From: Andrew M Volk <andrewmvolk@gmail.com>
To: Building Inspections <buildinginspections@portlandmaine.gov>
Date: 7/15/2015 8:40 AM
Subject: Re: Residential Deck Application.
Attachments: Setbacks.pdf; Plot.pdf

### Deck layout diagram

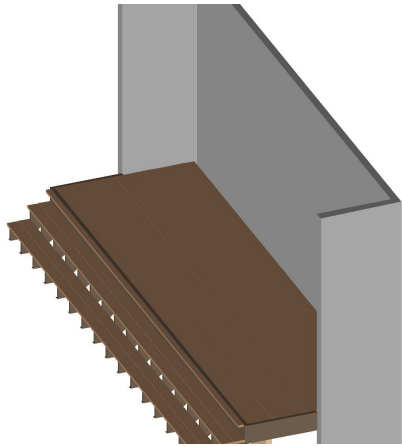
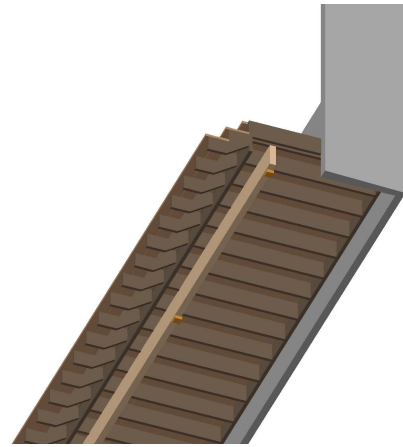
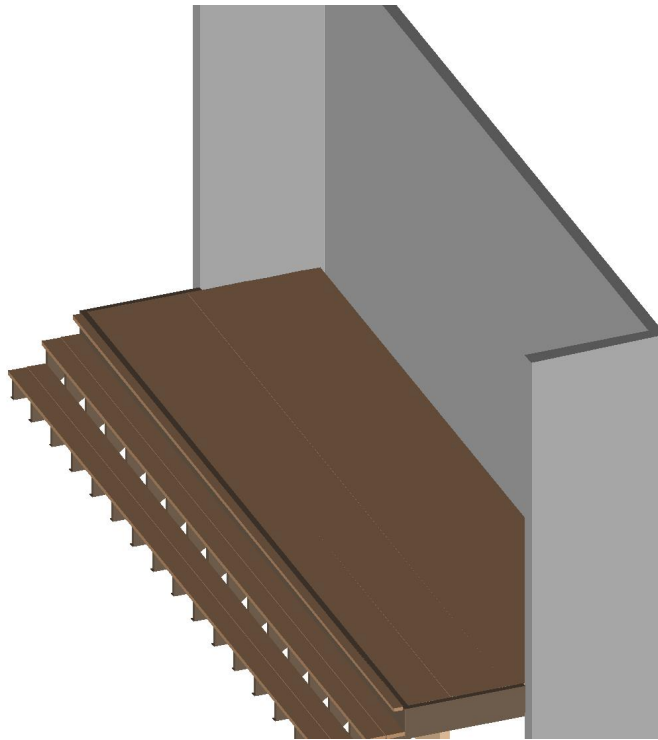
> Andrew, none of your plans show dimensions. Also, your plot plan must
> show the dimensions on all 4 sides to show setbacks. Once we get a
> complete application package we can enter it.
>
> >>> Andrew M Volk <andrewmvolk@gmail.com> 7/15/2015 1:12 AM >>>
>
> Building Inspections,
>
> Attached for your approval is a plan and application to build a deck at 4
> Kenwood St in Portland. If possible, I hope this application is placed on
> the Fast Track, as stated on your website.
>
> Please note, the deck will be attached to the current structure with a
> ledger board. Post locations are noted on attached documents.
>
> Thank you for your consideration and time.
>
> Best,
>
> Andrew Volk
>
> --
> Andrew Volk
> 503.869.9619
>
> --
>

Below is a plan with dimensions. And a second with a plot plan that has entire plot dimensions on it, for the purpose of showing setbacks.

Just so it's clear, the deck is a 20' by 6' square, surrounded on all sides by either building or a 2.5' wide stair that is 7" down.

The deck itself is 2" off of the front door, the step is 7" down from the deck and the ground is another 7" from that step (2.5' wide).
